WA:2544_8.109_PSC cover letter
Monday, 4 March 2019

**Re: SSD 8989 Catherine McAuley Catholic College, Medowie
Additional Information Requested to support Development Application**

Design Meeting Minutes

P0925 CMCC Access Design Analysis

NORTH

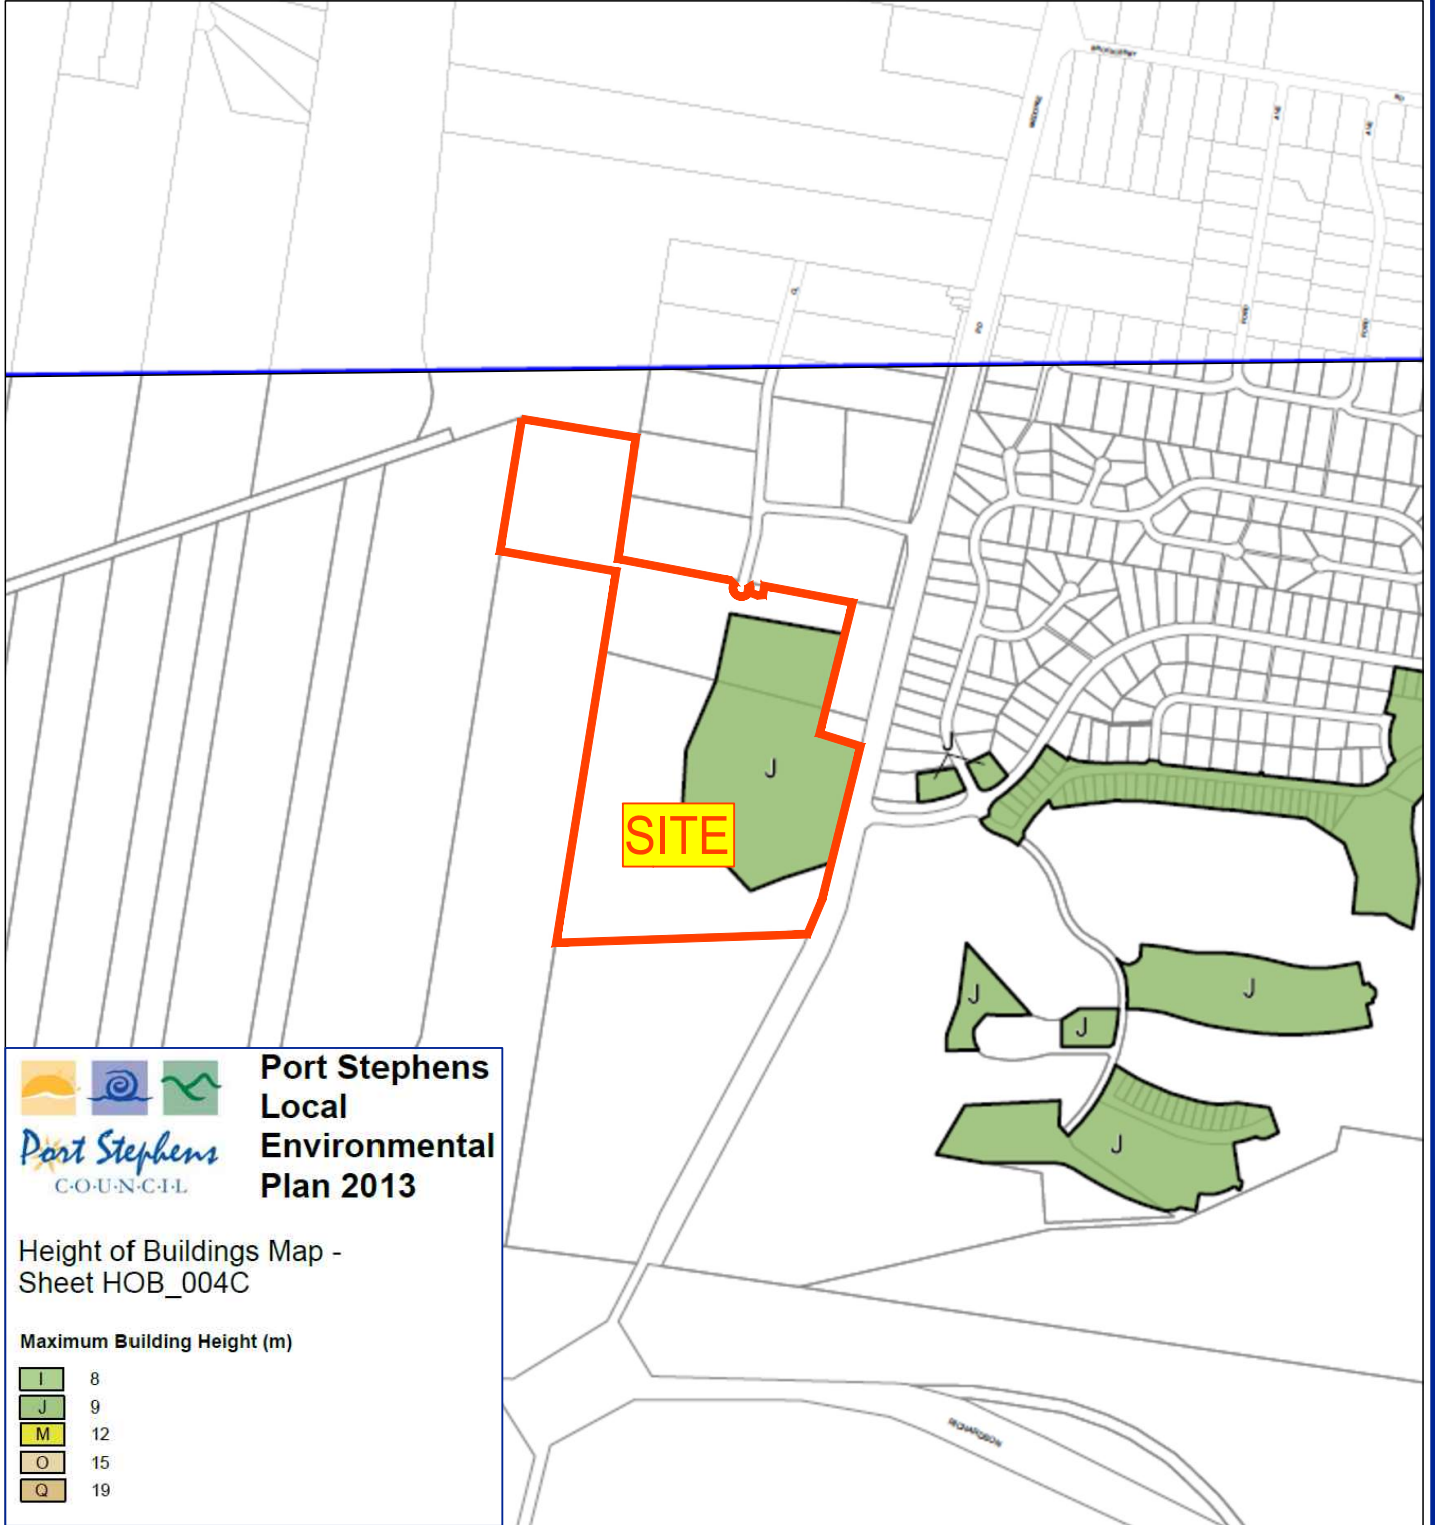
23.	JB queried why the culvert crossing under the roadway was square to the road and not tapered with the creekline to facilitate hydraulic flow. TH to request a response from the civil designer.	Webber Architects

The Civil engineer has advised the culvert shown on the concept civil roadway drawings follows the line of the existing culvert and creek bank. An extract of the site survey in this area is enclosed for reference.
